Your Ref:
Our Ref: R/49/09/
Please ask for:
Mrs J Chapman

20th April 2009

House & detached garage (Amendment to previously approved R/271/08).
8 Bushby Avenue Rustington

BLOCK PLAN Scale 1:500

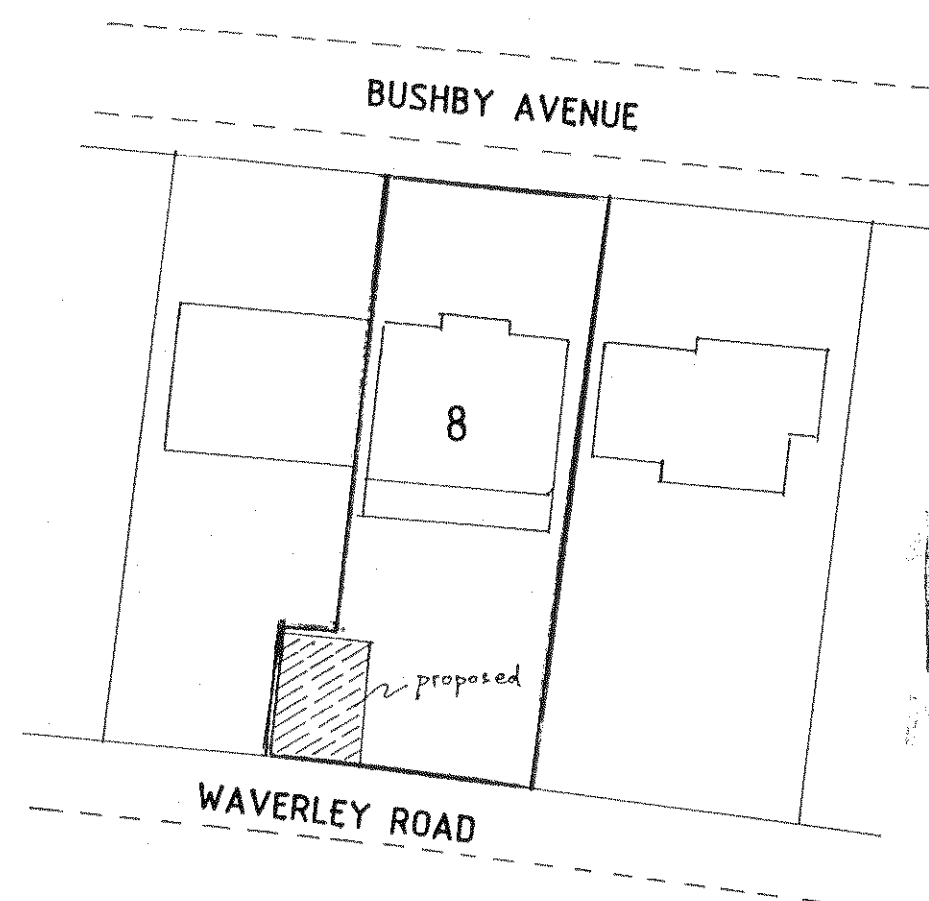
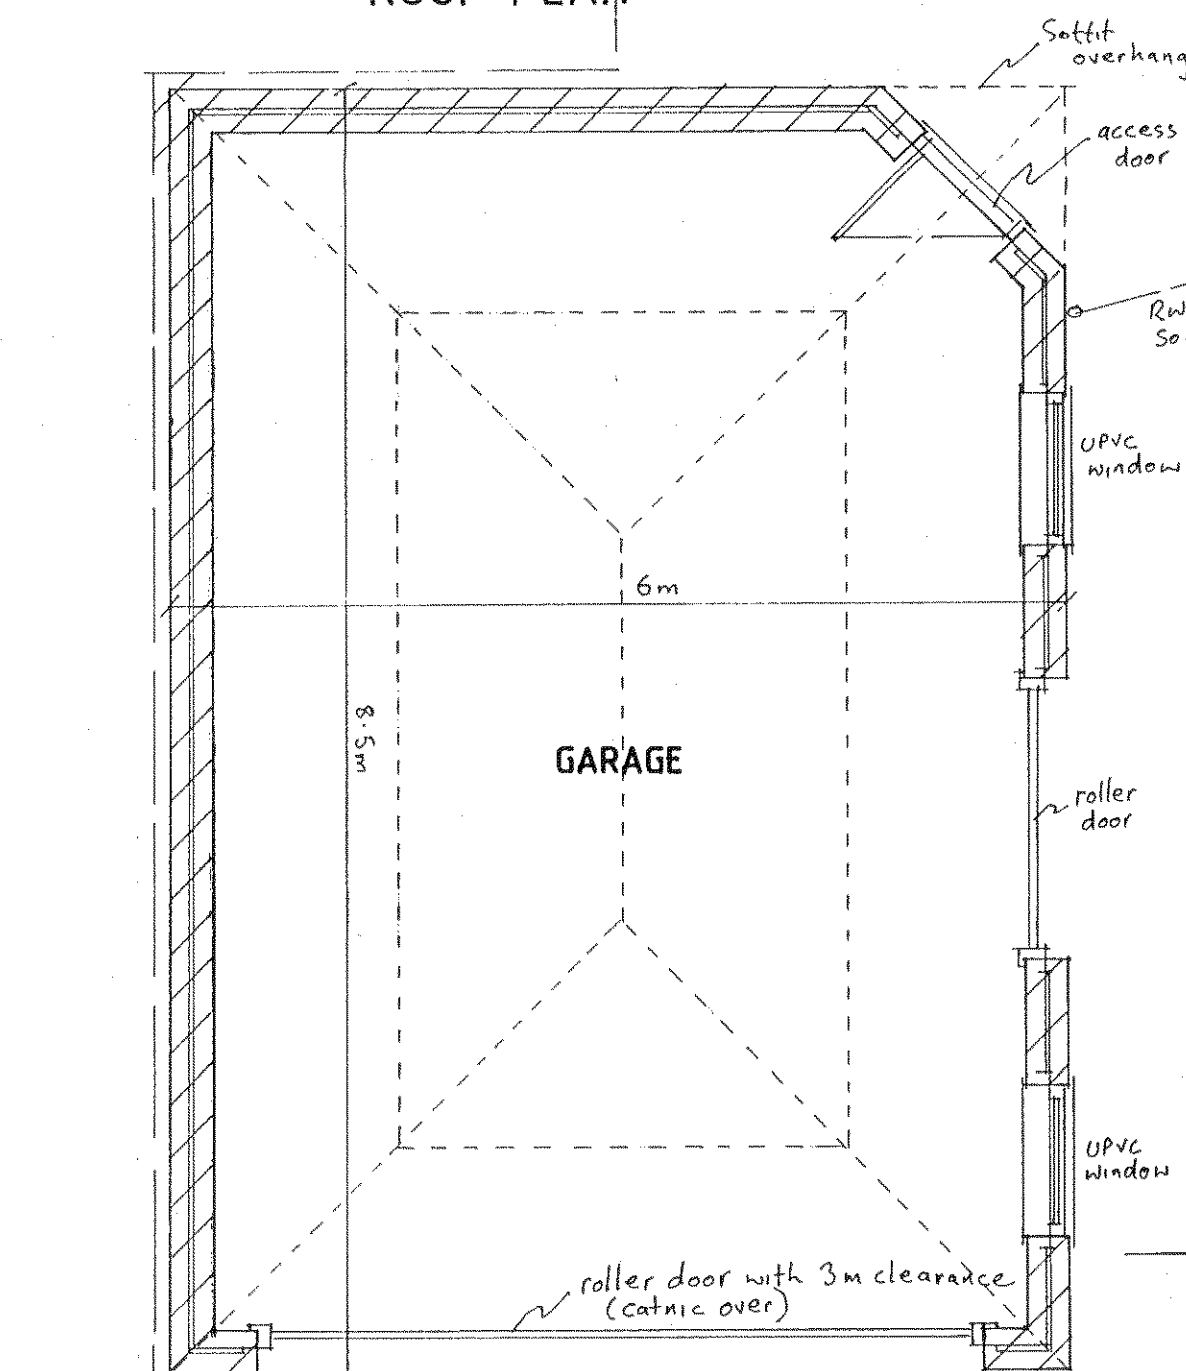
(i) In respect of the proposed garage, the formation and use of a vehicle access to the public highway at this point would add to the hazards of highway users to an unacceptable degree, and the introduction of a new vehicle access on a stretch of the road, namely Waverley Road, where no accesses of this type currently exist, would most certainly prove to be to the further detriment of highway users ☐

(ii) The proposal would, if approved, create a precedent which could result in more similar proposals in the vicinity, the cumulative effect of which would be to alter the character of the locality to the serious detriment of the amenities of the area. ☐
